Our ref: HA/2021/122860/01-L01
Your ref: WA/99/20/DOC
Date: 26 January 2021

APPROVAL OF DETAILS RESERVED BY CONDITION IMPOSED UNDER REF APP/C3810/V/16/3143095 (WA/22/15/OUT) RELATING TO CONDITION NOS 6 - MATERIALS AND FINISHES, 12 - SURFACE WATER DRAINAGE, 13 - INFILTRATION OF SURFACE WATER DRAINAGE, 14 - MAINTENANCE & MANAGEMENT OF SUDS, 15 - FOUL DRAINAGE AND 27 - EMERGENCY ACCESS FROM SITE ONTO ARUNDEL ROAD

LAND TO THE EAST OF FONTWELL AVENUE FONTWELL

Typical Geocellular Soakway Detail

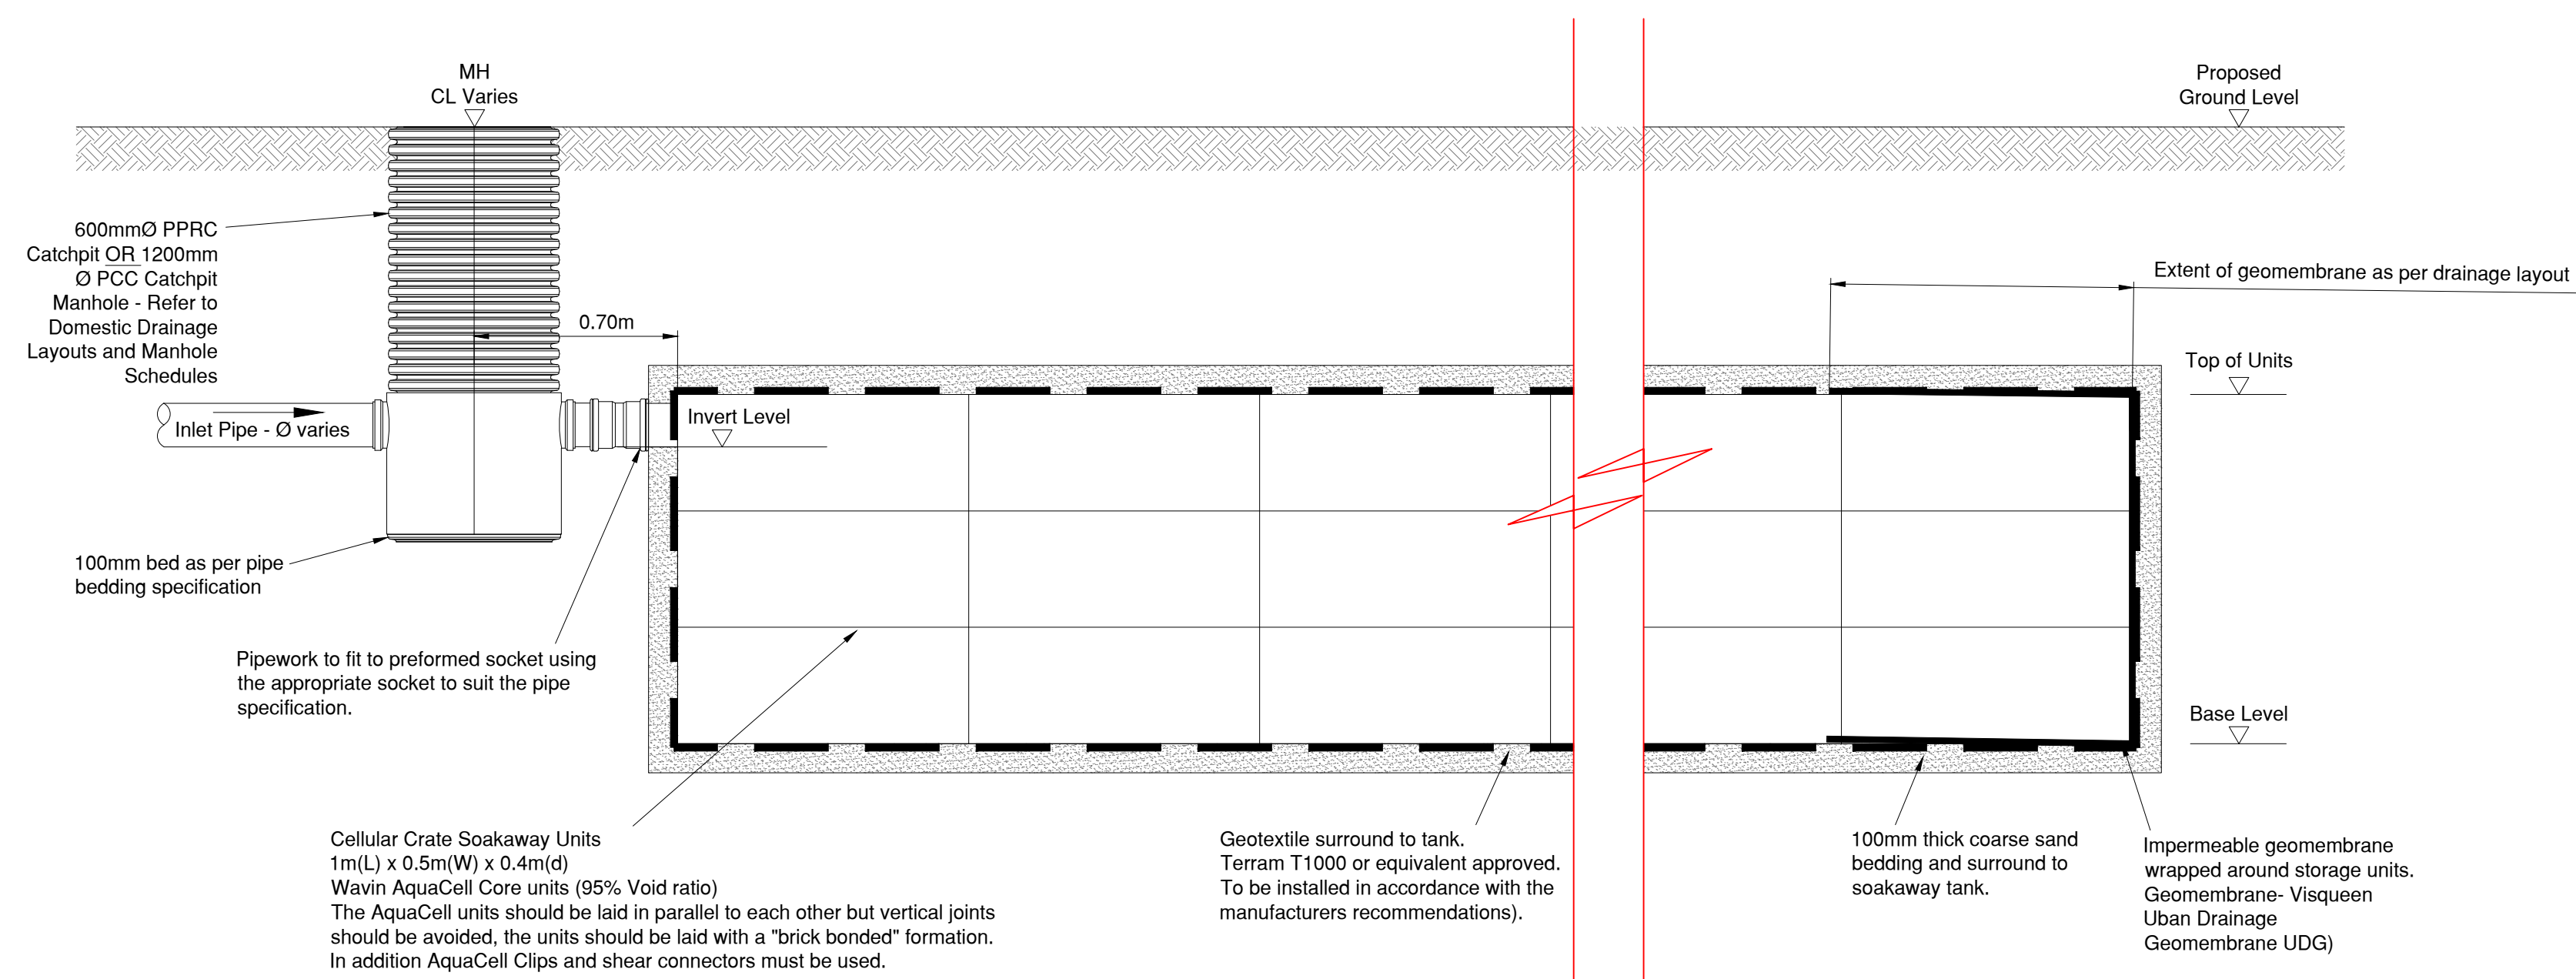
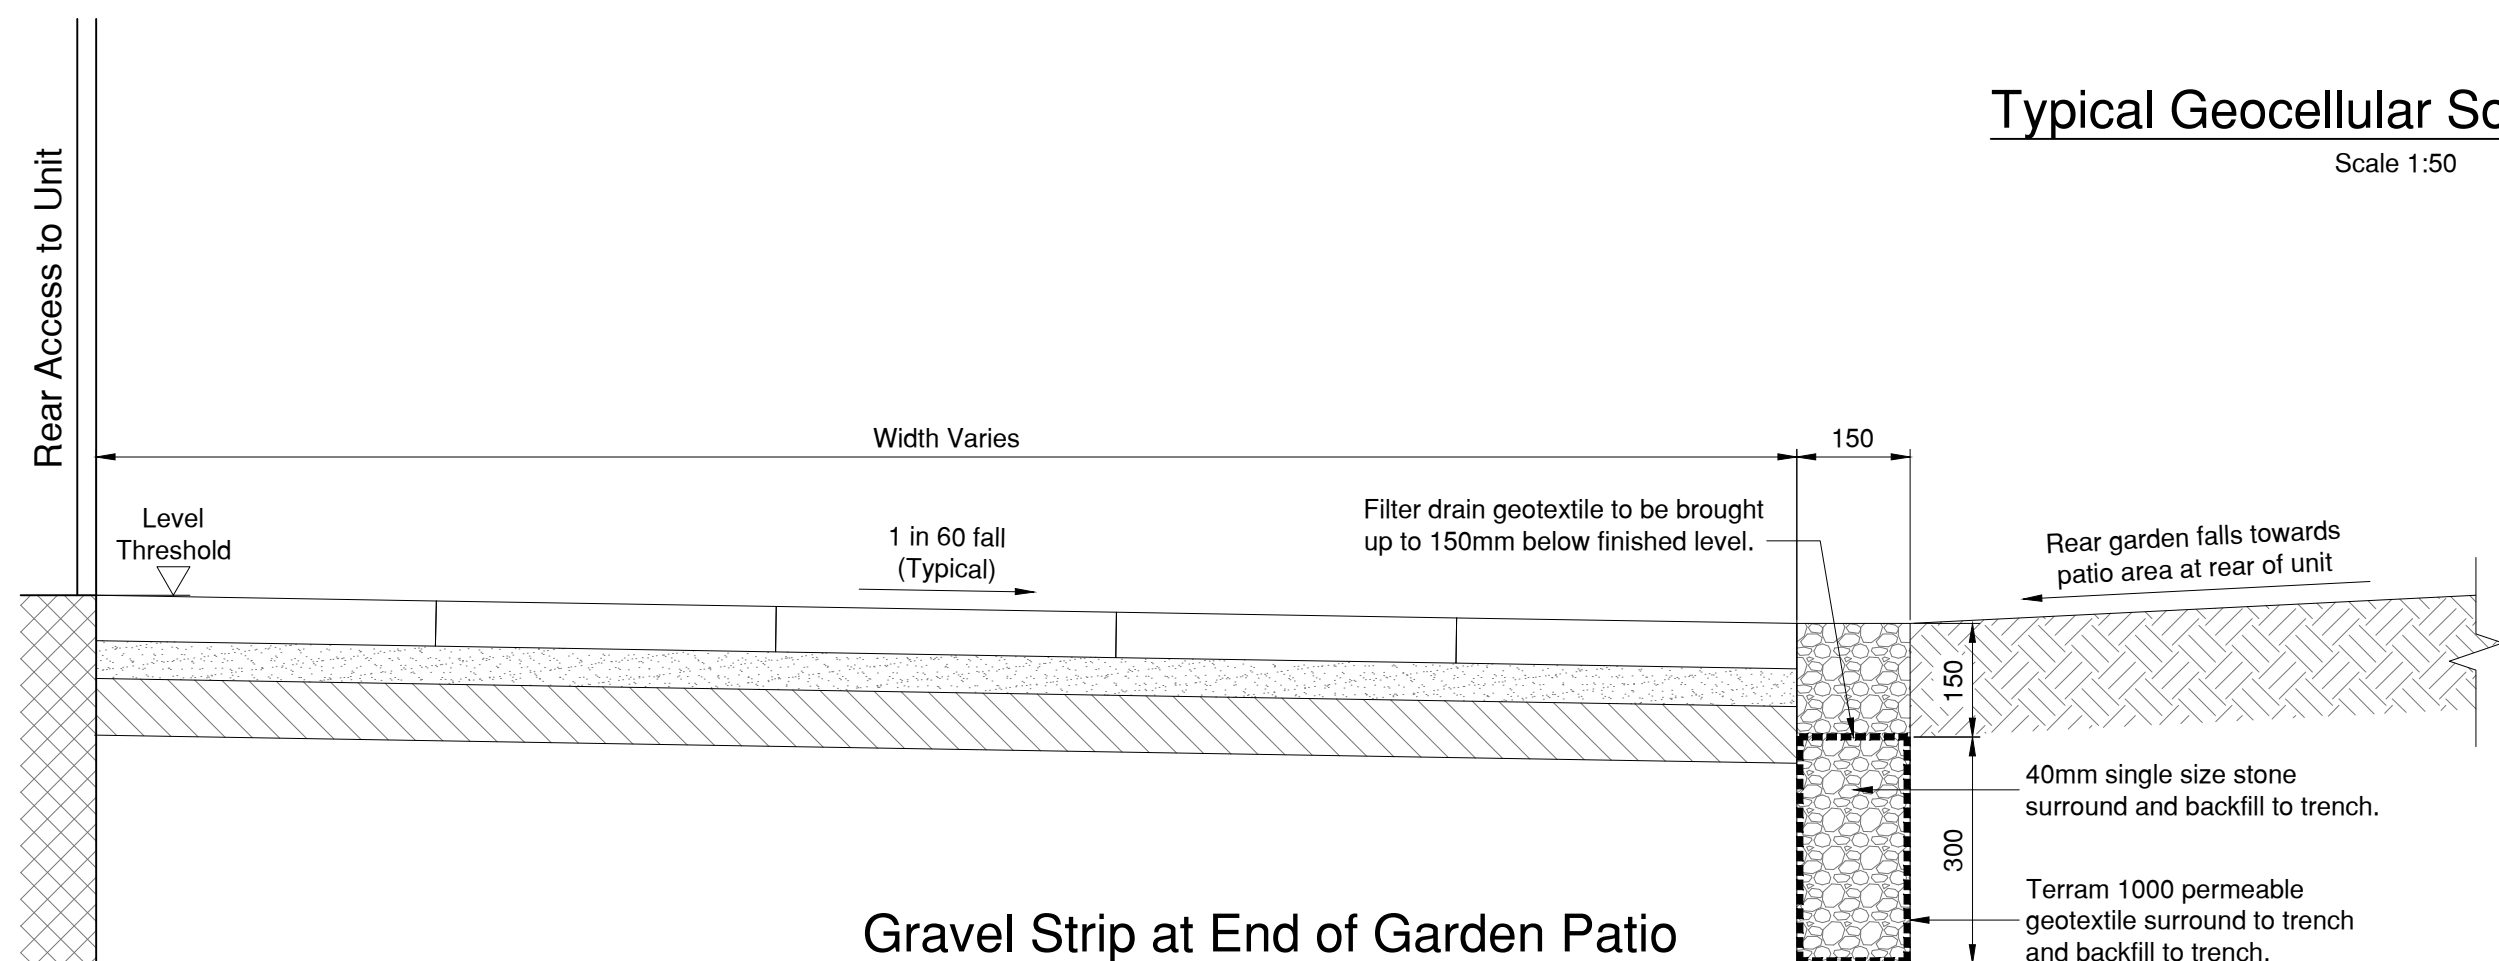
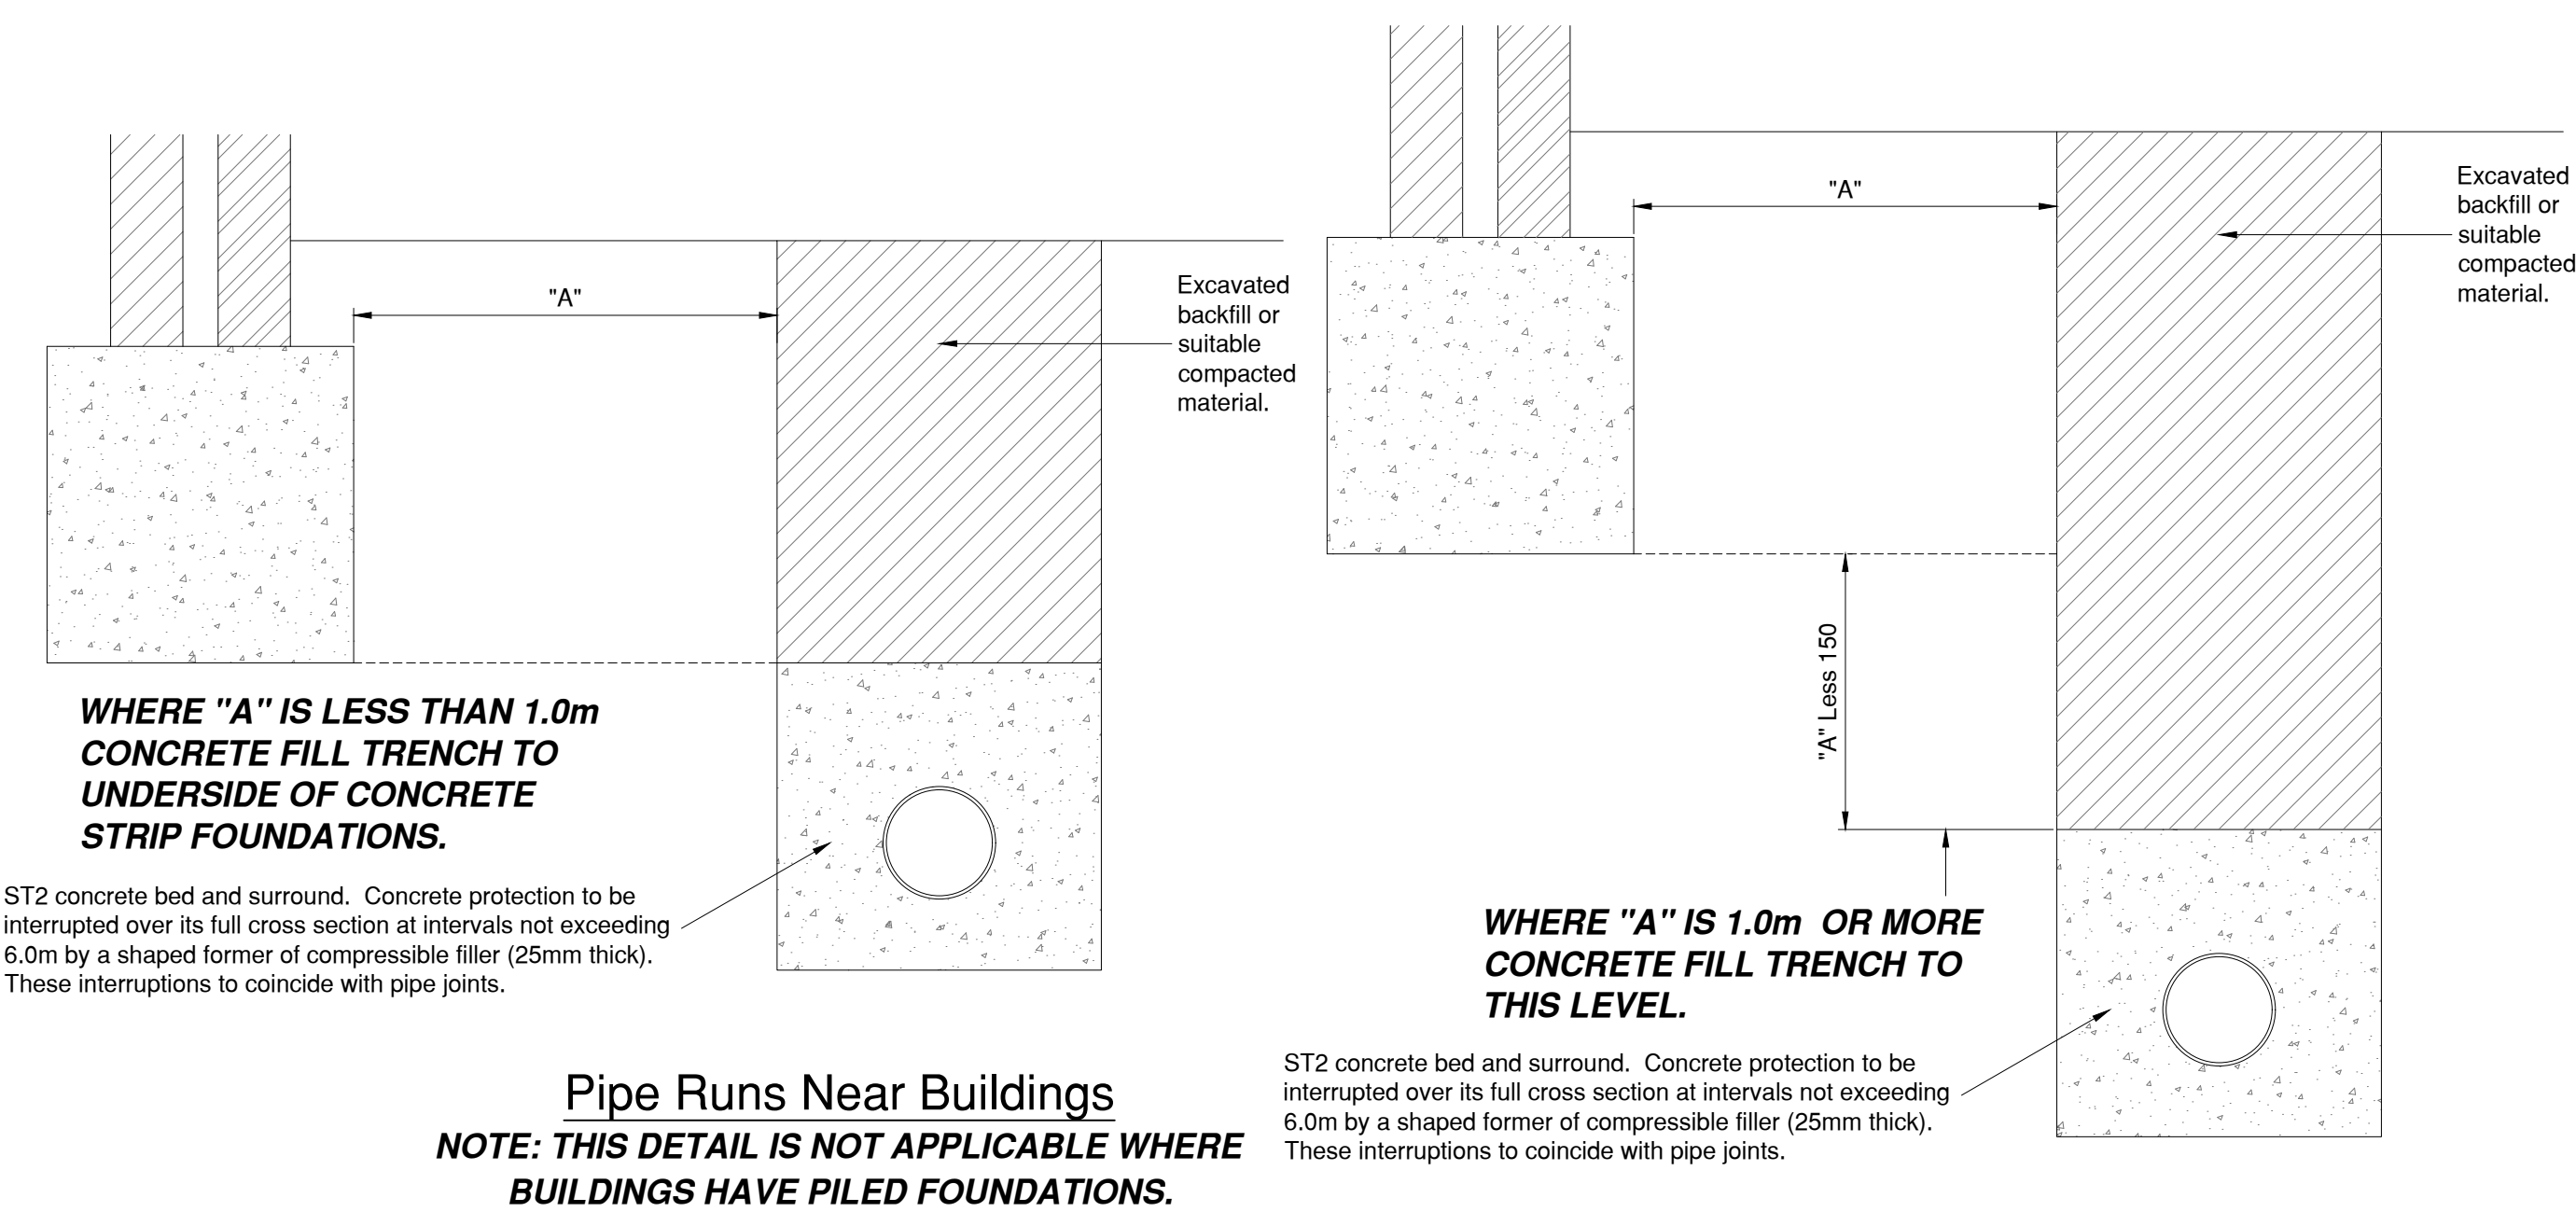
We support the proposal to use the CIRIA SuDS Manual to mitigate against the risk to groundwater. However we **are unable to discharge** this condition at present as we have been unable to review documents for the construction details of the soakaways, in particular their maximum depth. We require soakaways to be as shallow as possible to reduce the risk to the underlying aquifer.
